# CONSTRUCTION PLANS FOR HILLSIDE AT LORSON RANCH FILING NO. 1 STREET & STORM SEWER CONSTRUCTION PLANS

**HILLSIDE AT LORSON RANCH FILING NO. 1  
STREET & STORM SEWER  
CONSTRUCTION PLANS**

DATE:  
DEC 1, 2022  
PROJECT NO.  
100.065  
SHEET NUMBER  
**C1.1**  
TOTAL SHEETS: 47

Signing and Striping Notes:

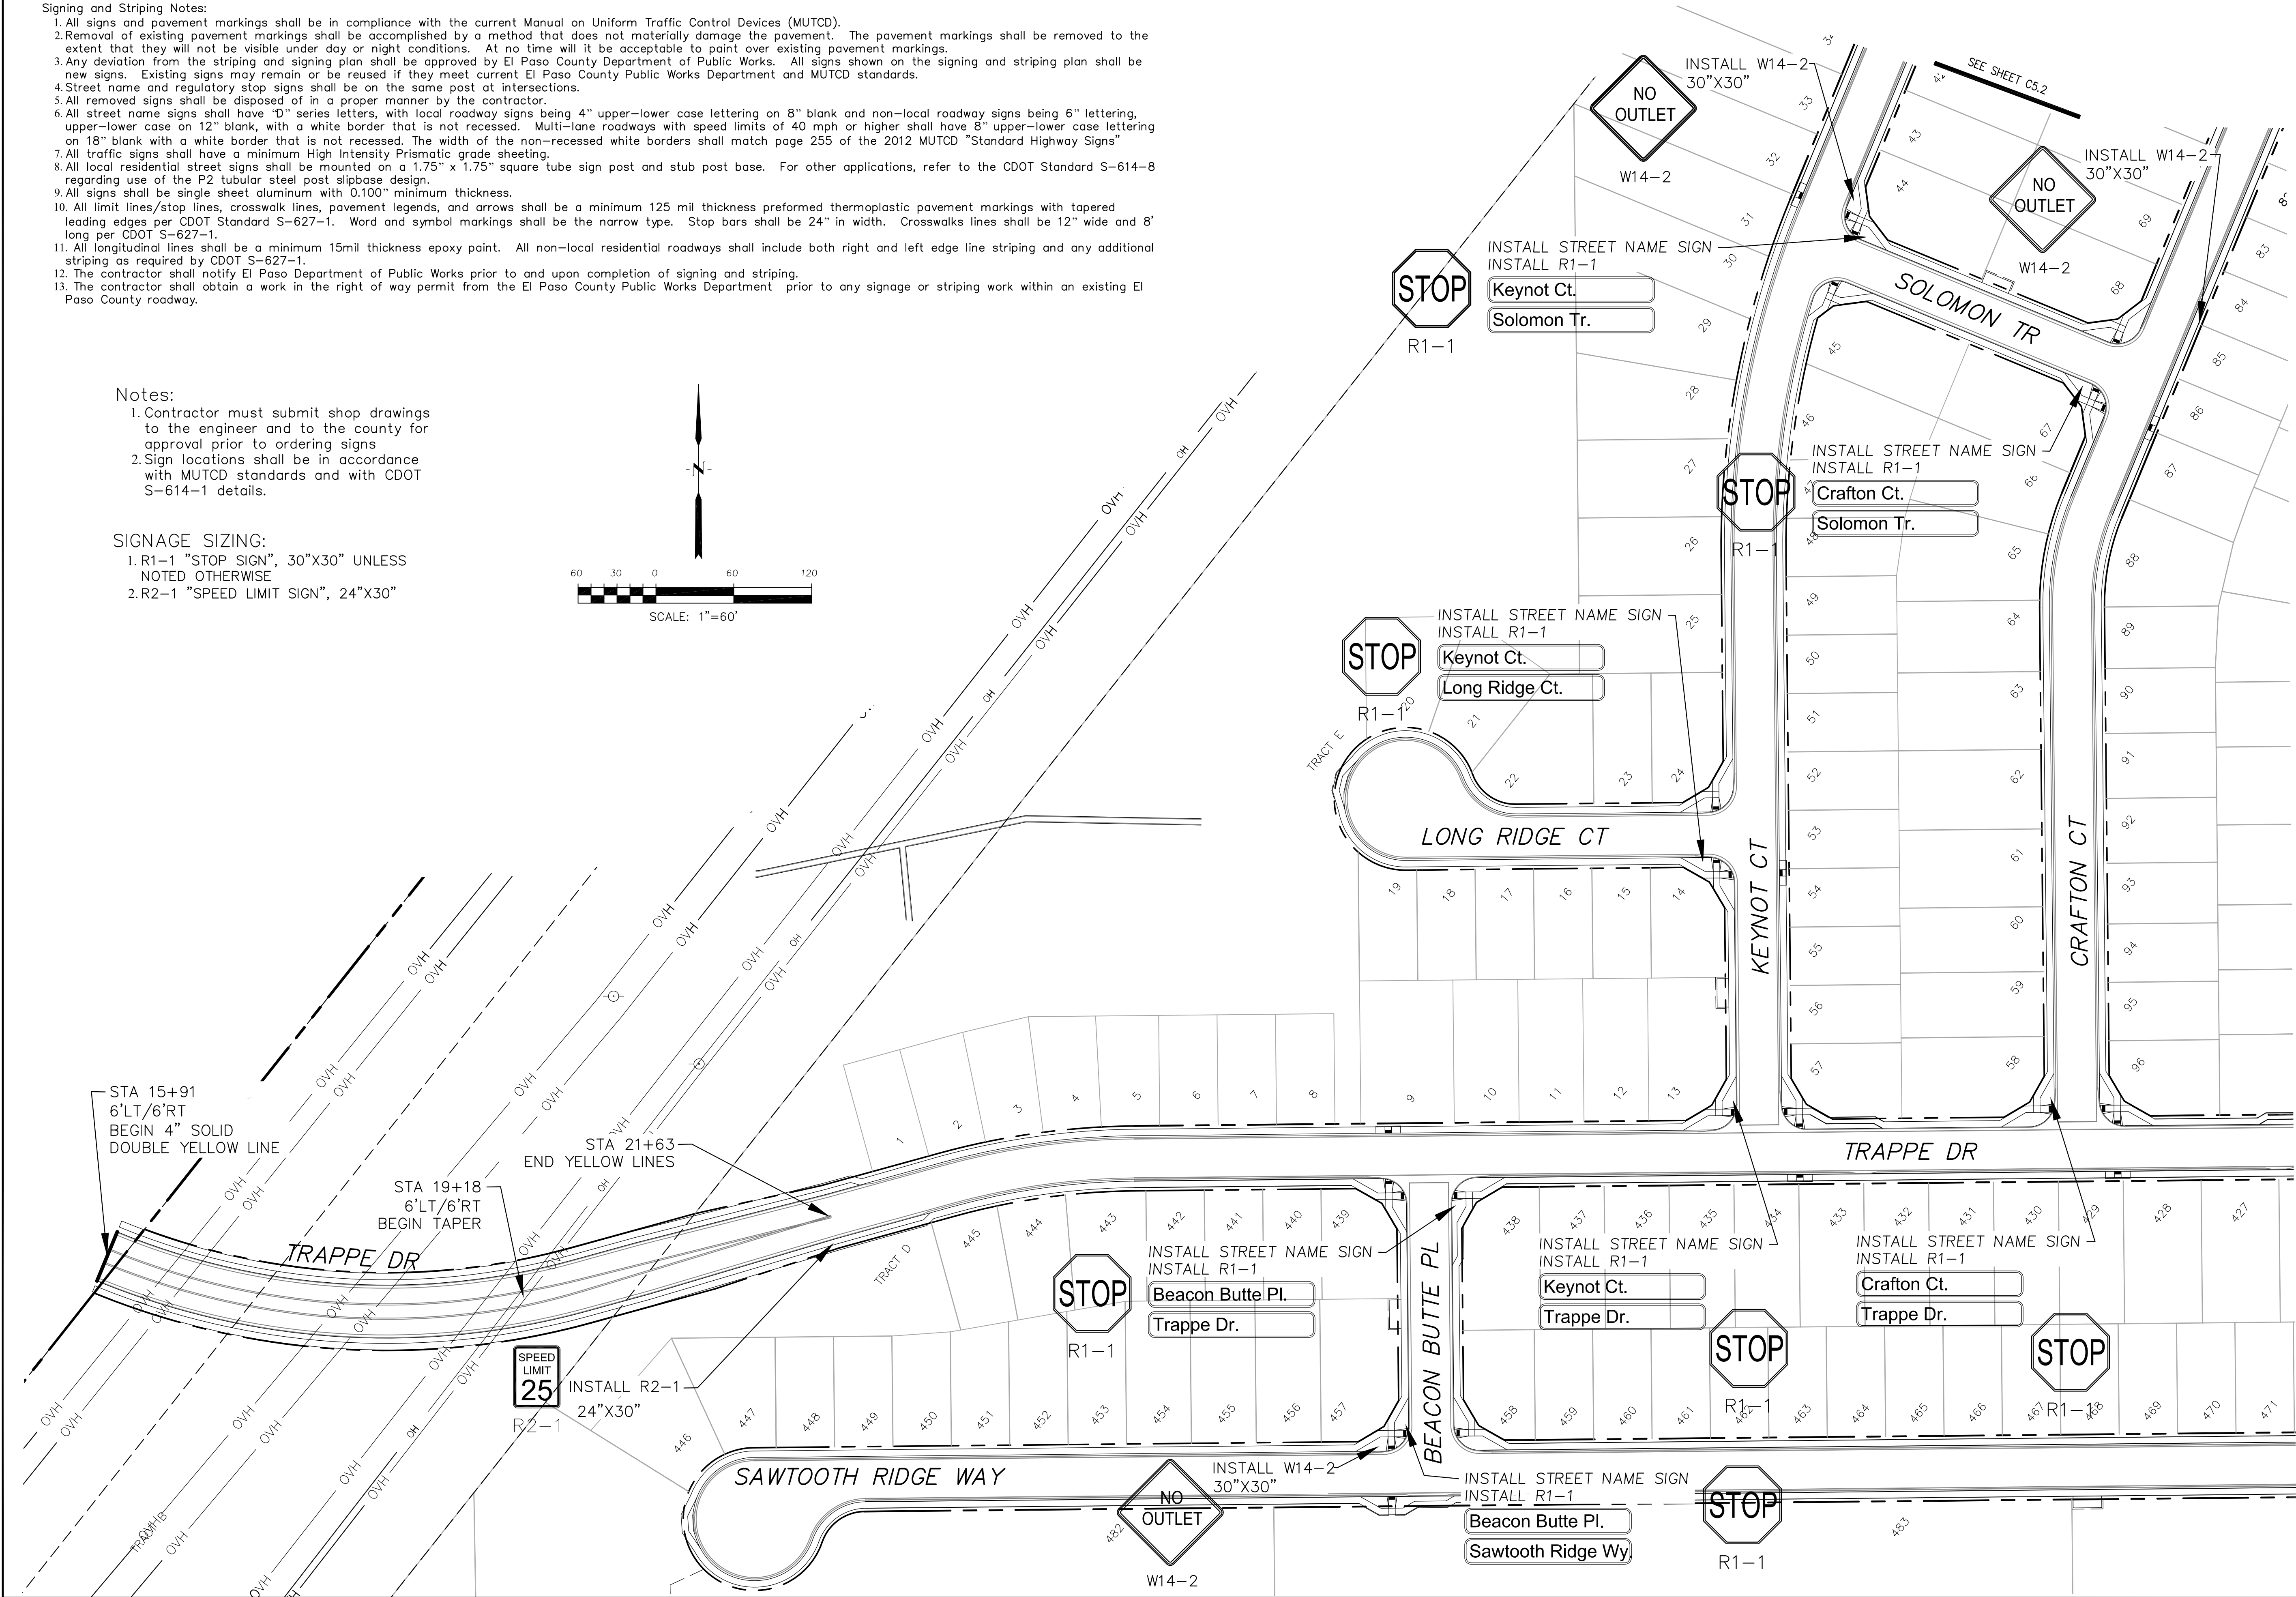
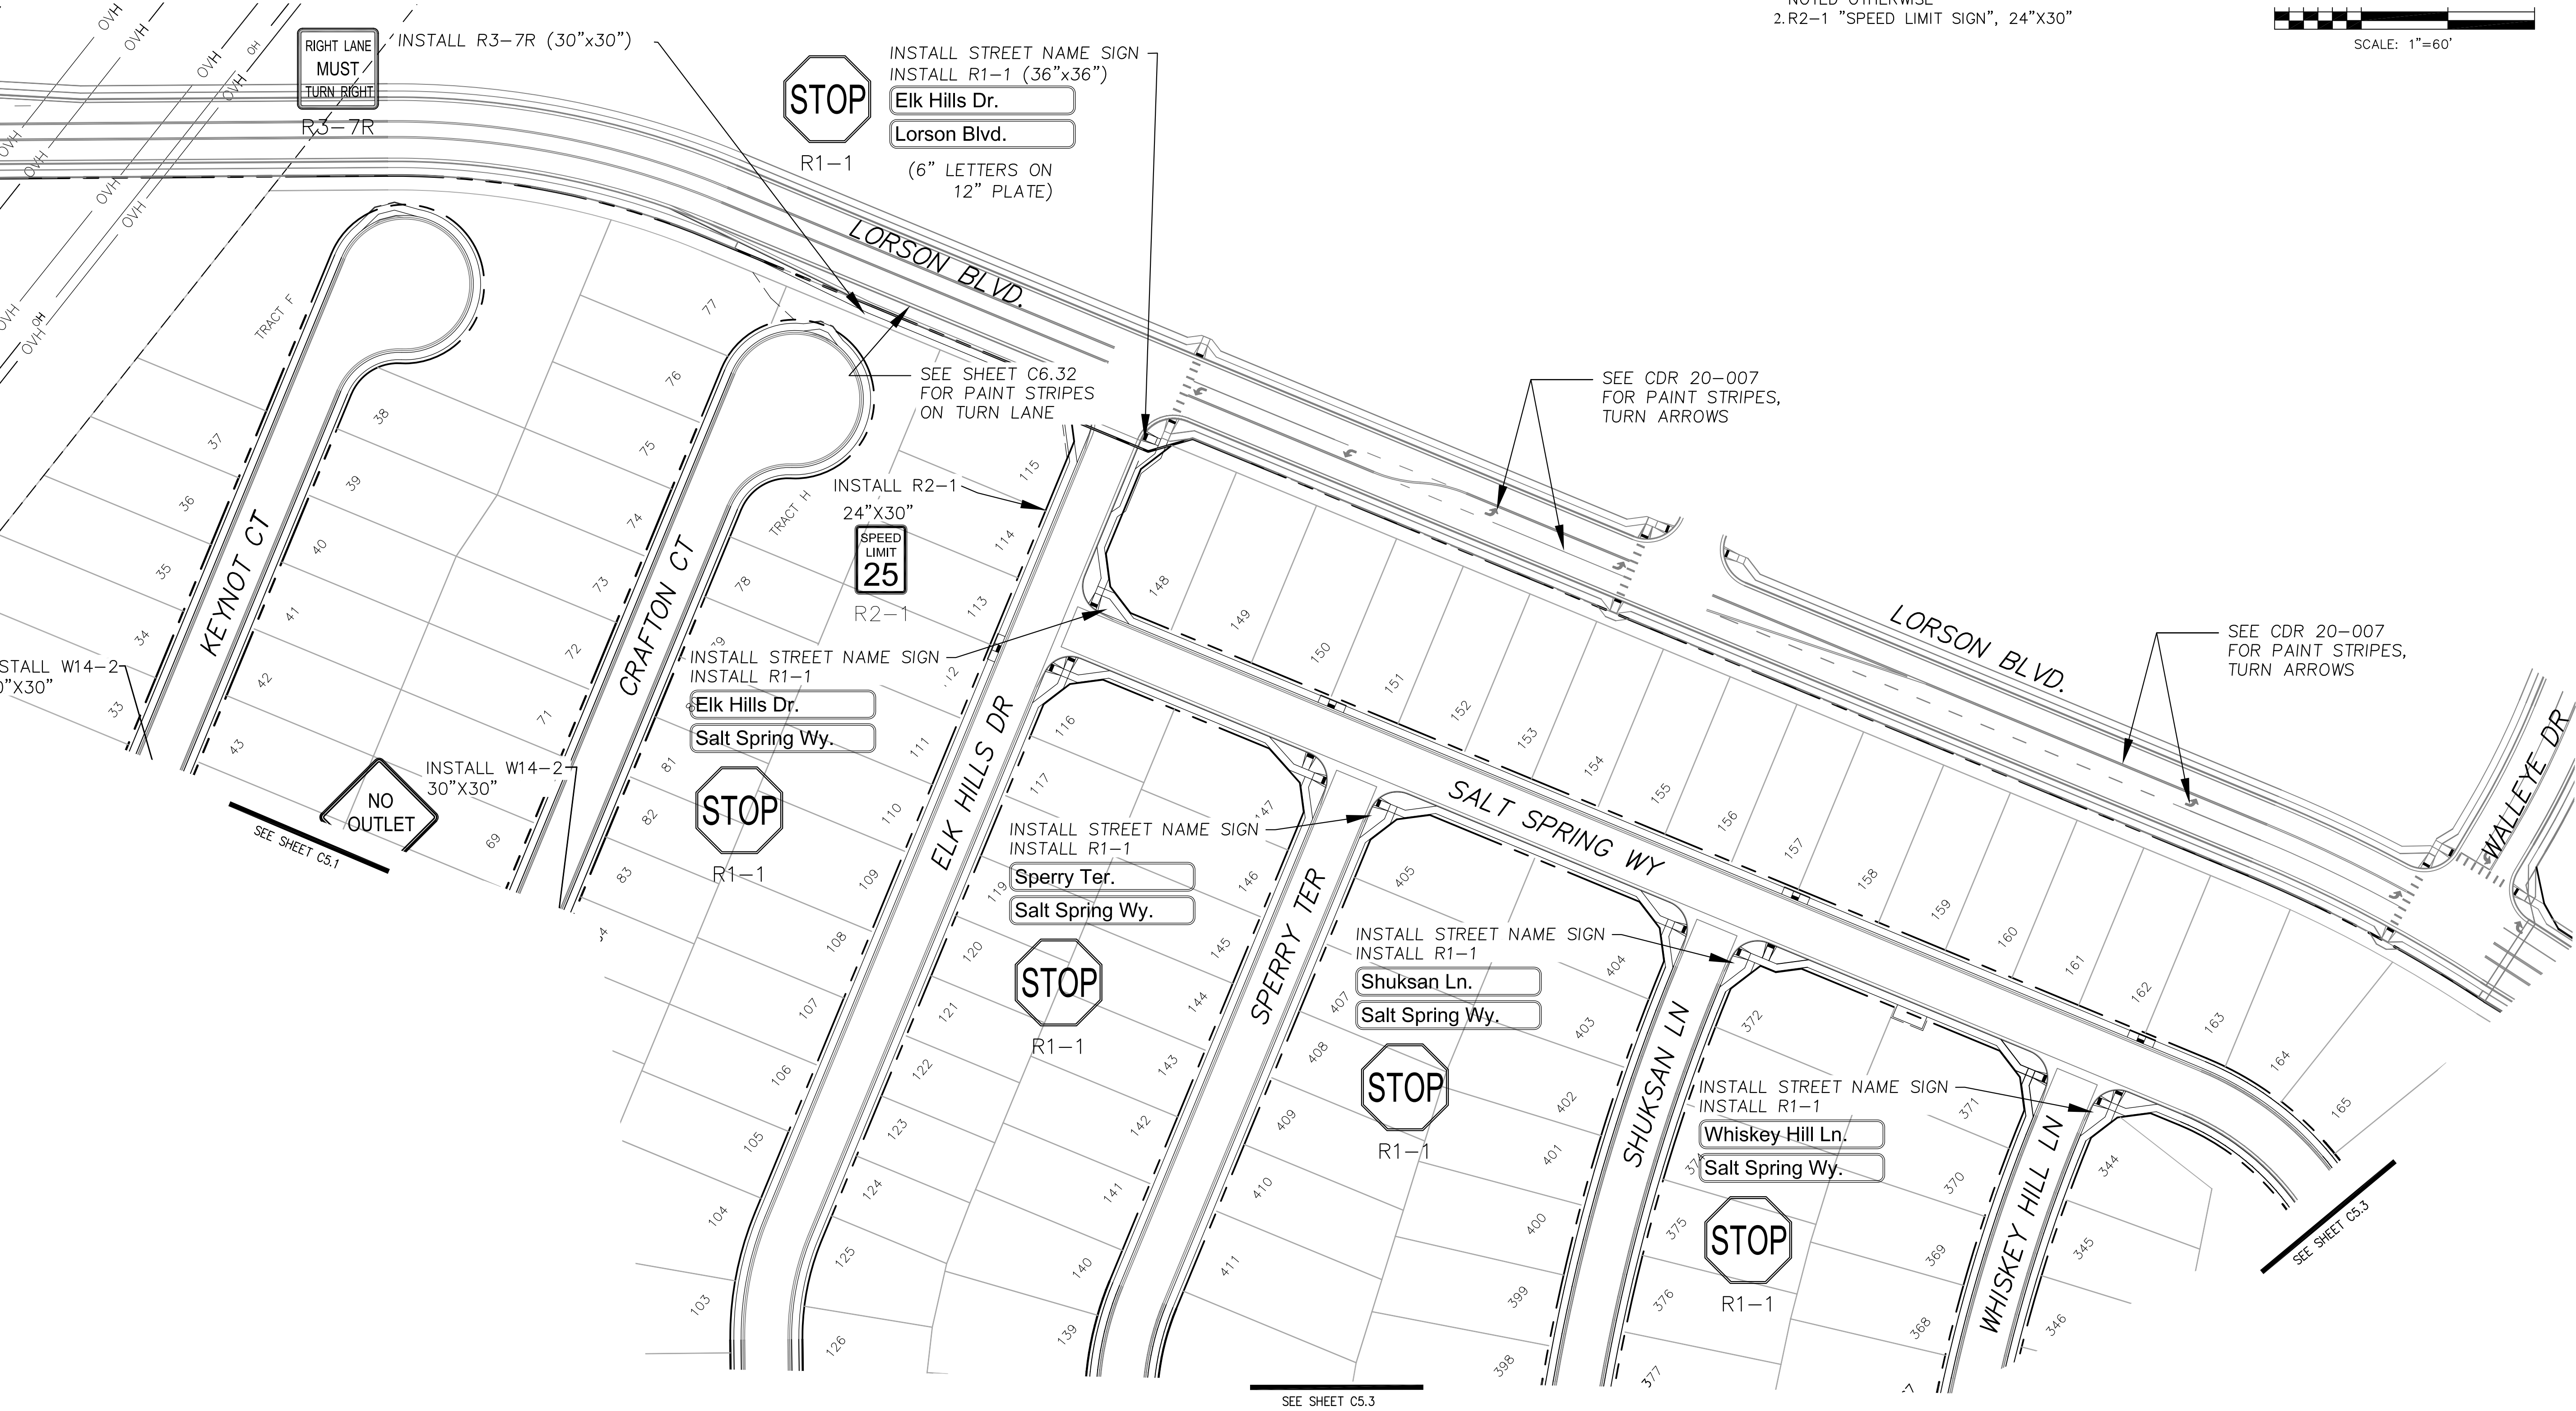
Change "Planning and Community Development" as highlighted in notes, to "Department of Public Works"
